Application no: H12/1269/98

Description: Residential development
(7 dwellings with detached
garages)

Location: Garnsgate Road
Long Sutton
Spalding
Lincs

Amendment: Increase depth of bungalow (main part) by 900mm and alter
internal layout (Plot 1)

DRAWING REF:- HOOK THAW/ PLOT 6.

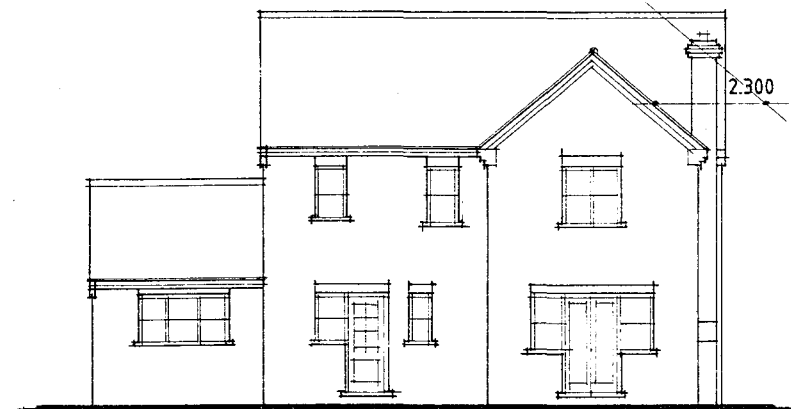
Amendment: Increase width of main part of house by 600mm, splay bays
instead of square bays, conservatory at rear

1. INCREASE WIDTH OF MAIN PART OF HOUSE BY 600MM
2. SPLAY BAYS INSTEAD OF SQUARE BAYS.
3. CONSERVATORY AT REAR (OFF LOUNGE)

DEE CONSERVATORY.

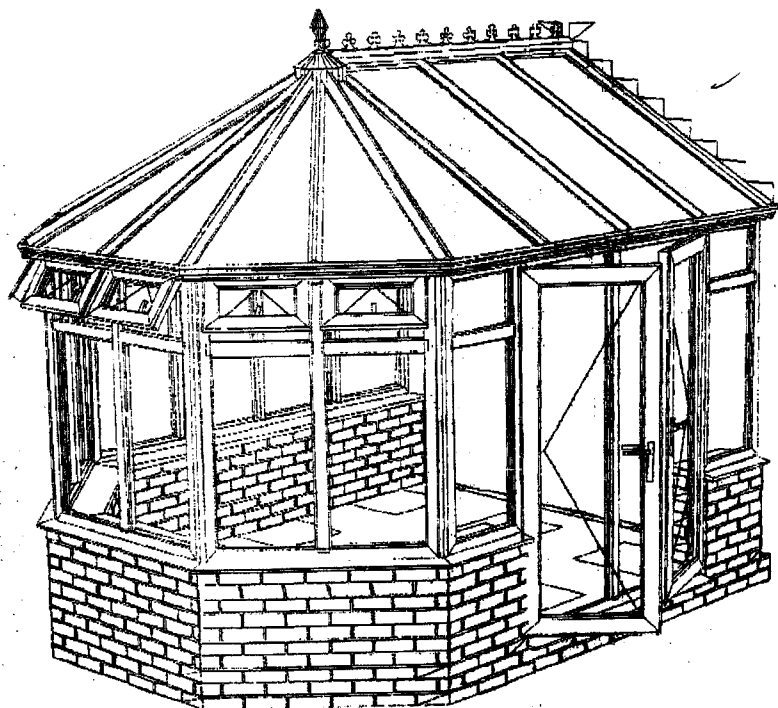
Amendment: Plot 4 - Add conservatory off lounge

CONSERVATORY OFF LOUNGE

— APPROVED PLAN 9.100M OA —
 — AMENDED PLAN 9.700M OA —

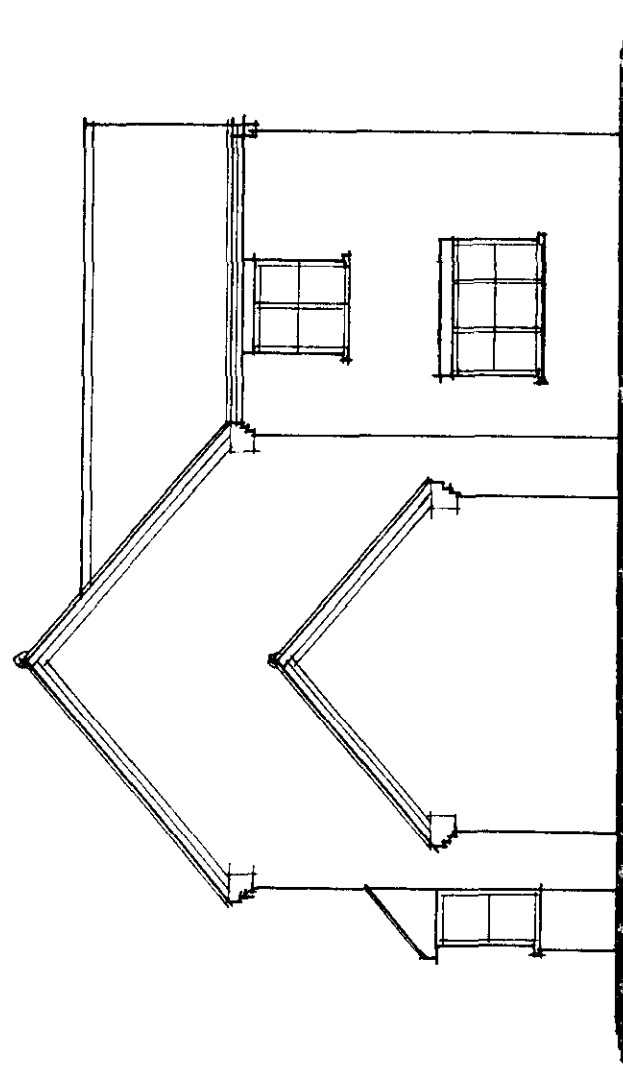
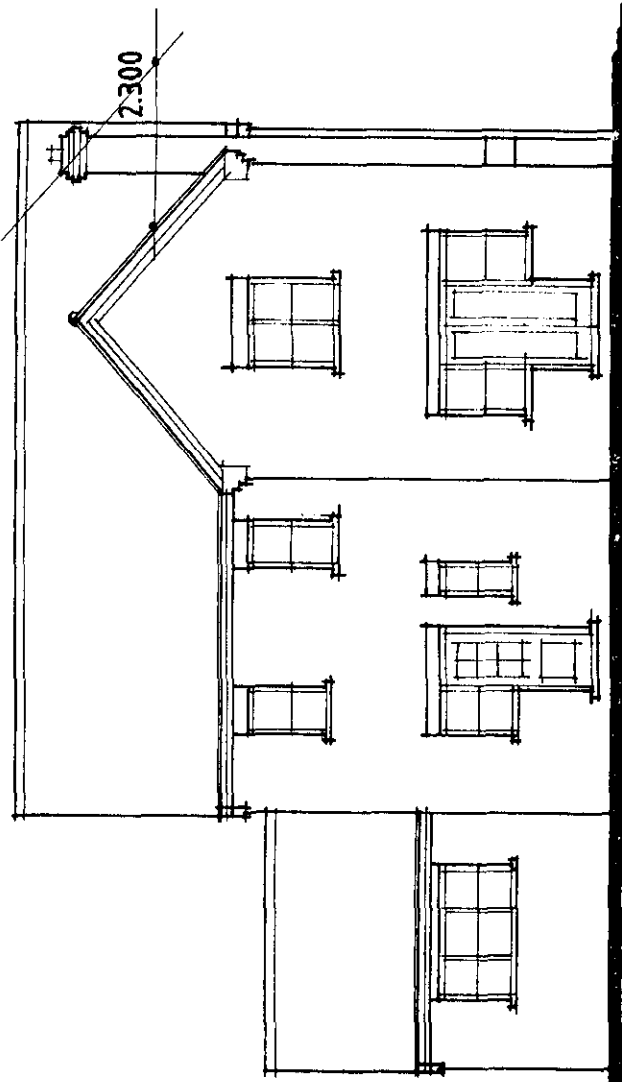
1. INCREASE DEPTH OF BUNGALOW
(MAIN PART) BY 900MM
2. ALTER INTERNAL LAYOUT.
